***The Planning Act 2008 - Chapter 2 Examination TR010025
A303 Amesbury to Berwick Down Improvements***

***Written Submission by the Council for British Archaeology
and CBA Wessex***

May 2019

**SUPPLEMENTARY OBSERVATIONS
ARISING FROM MATERIAL DEPOSITED FOR DEADLINES 1 & 2
PART A – ARCHAEOLOGICAL SURVEY REPORTS AND DRAFT
MITIGATION STRATEGY**

- Figure 51 Comparison of Geophysical survey interpretation: Areas west of Longbarrow roundabout**

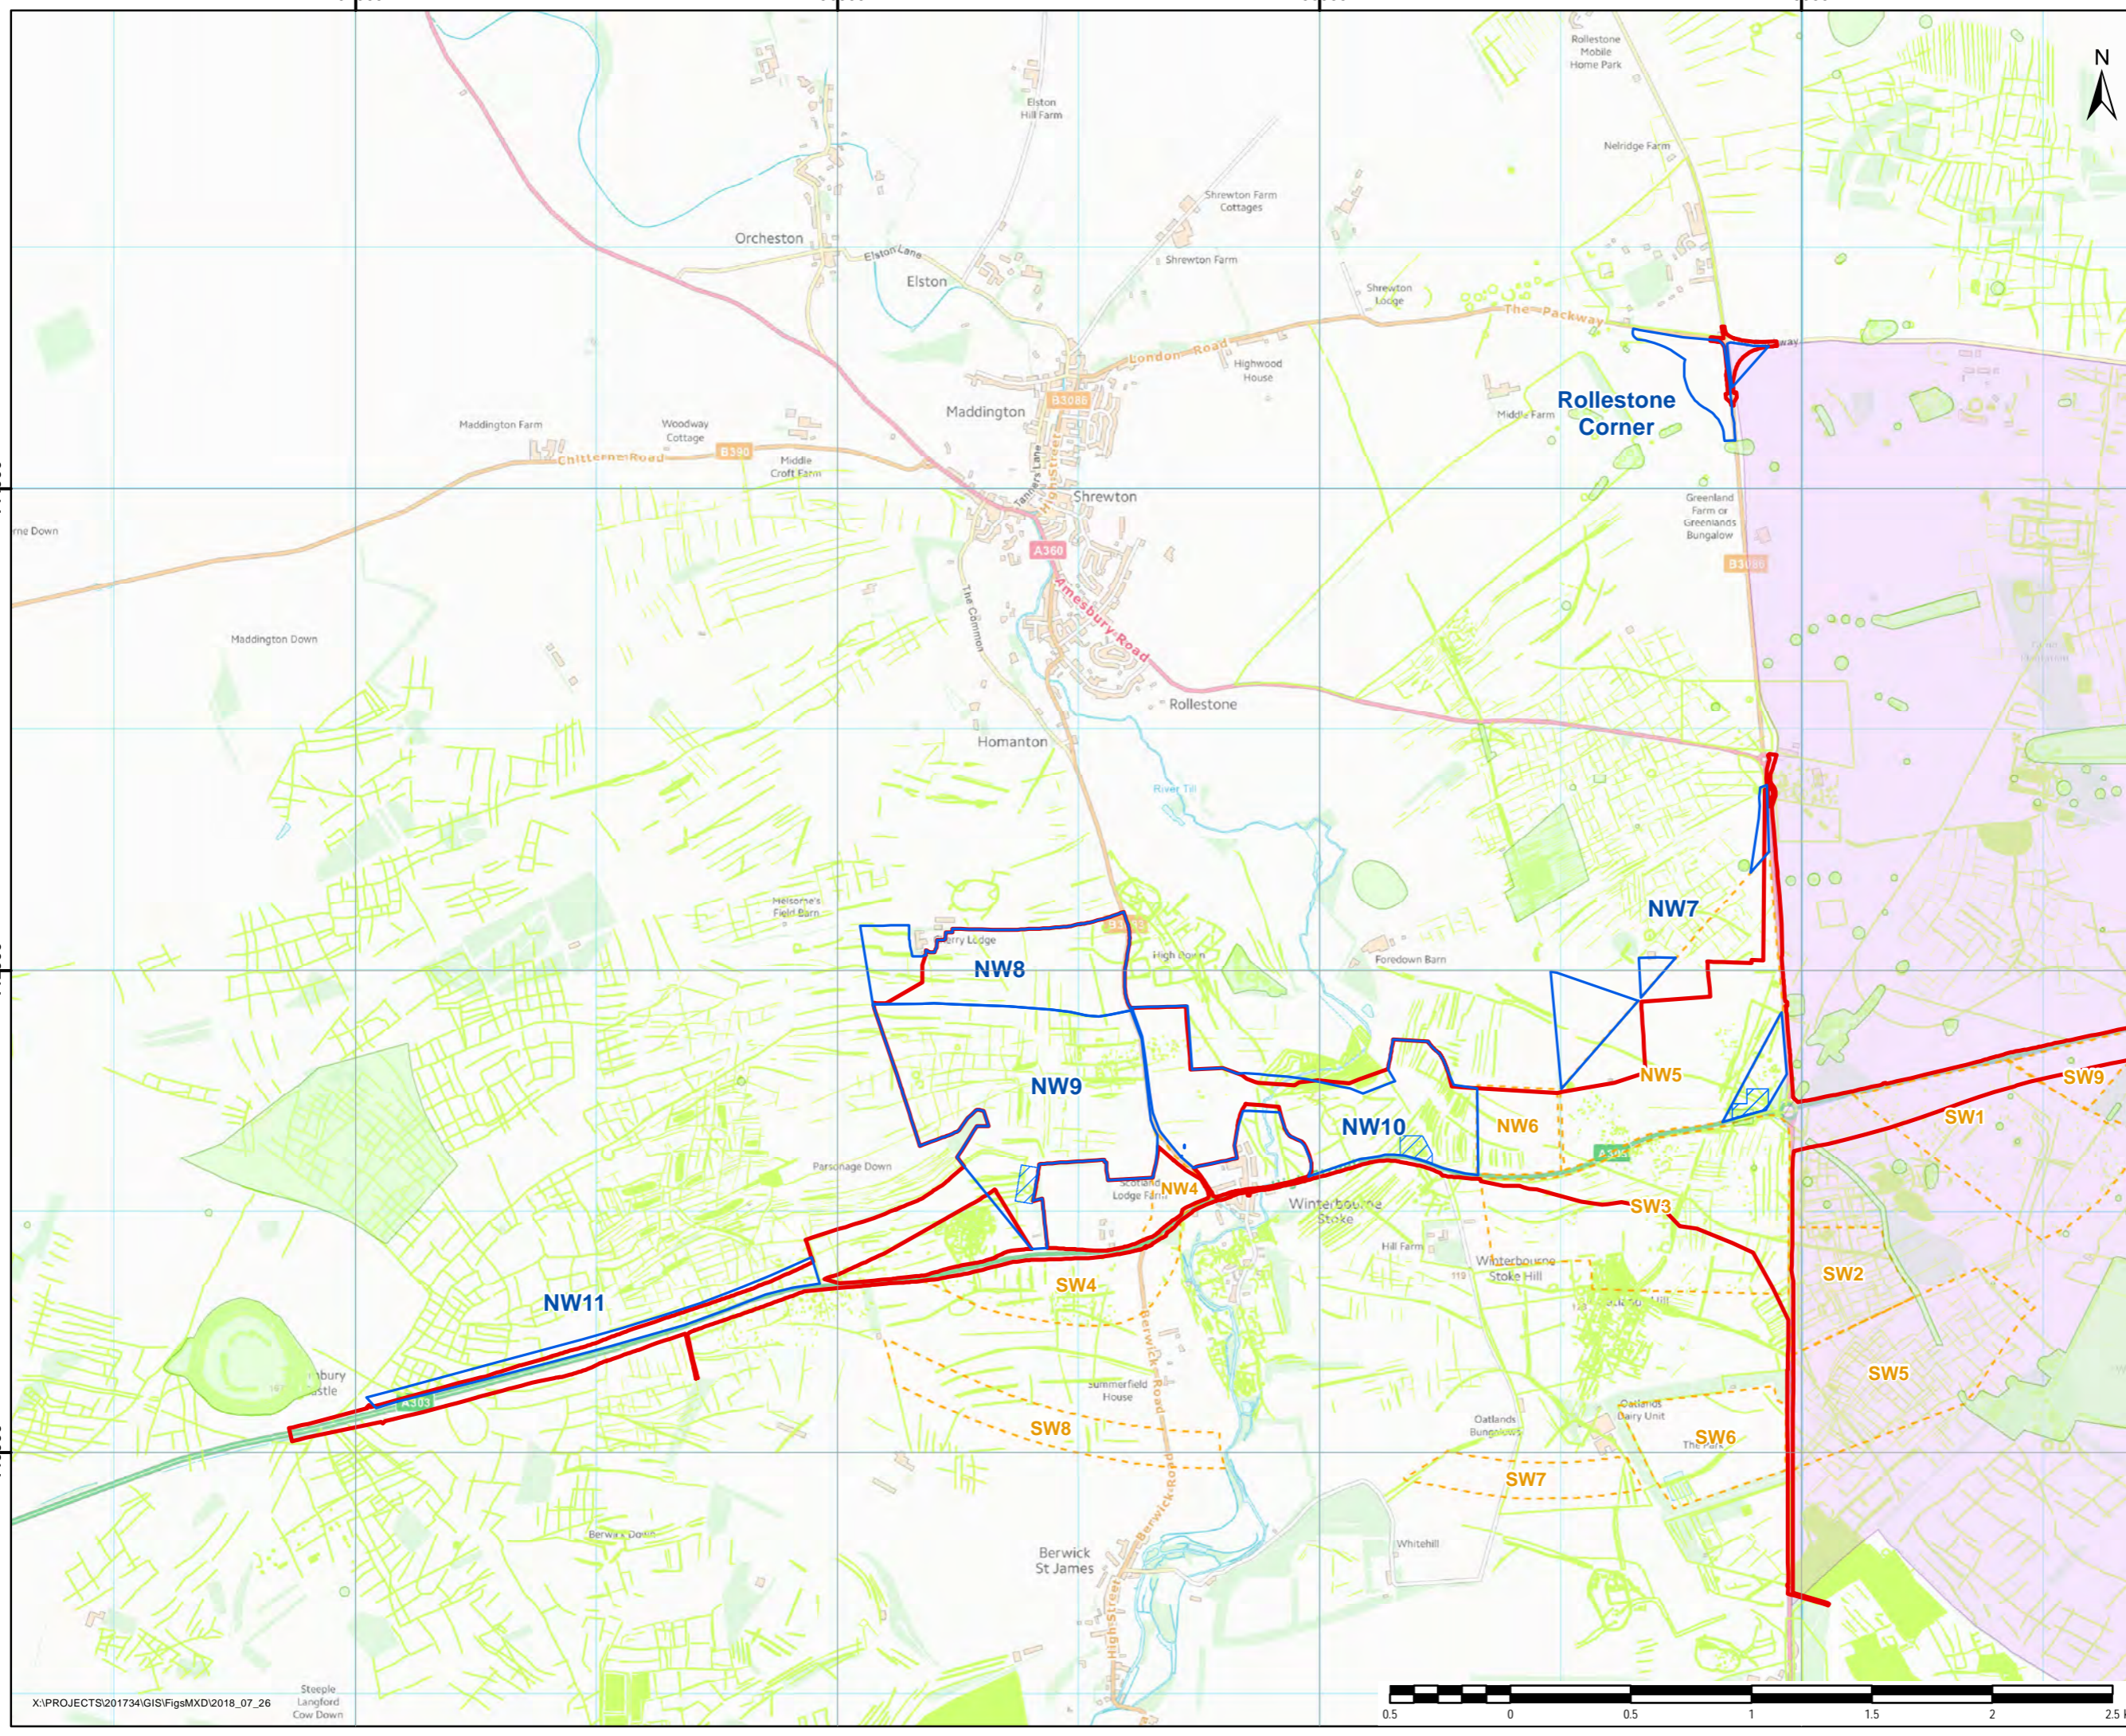
20. The differences arising from this change in sampling standard are described in Appendix A, with a very helpful comparative plan of the one area covered by both methods. It is stated that

22. However, this discussion does not deal with the issue of much smaller features such as pits and flat graves. The overlaid plans show two further distinctions:

- Several of the 'possible archaeology' linear anomalies identified by the older work have been resolved into clusters of individual anomalies of 'possible archaeology'

- Many more isolated 'possible archaeology' anomalies have been identified.
23. Whether the difference in sampling rates matters is debateable, especially as most of the scheme has been covered to the higher resolution.
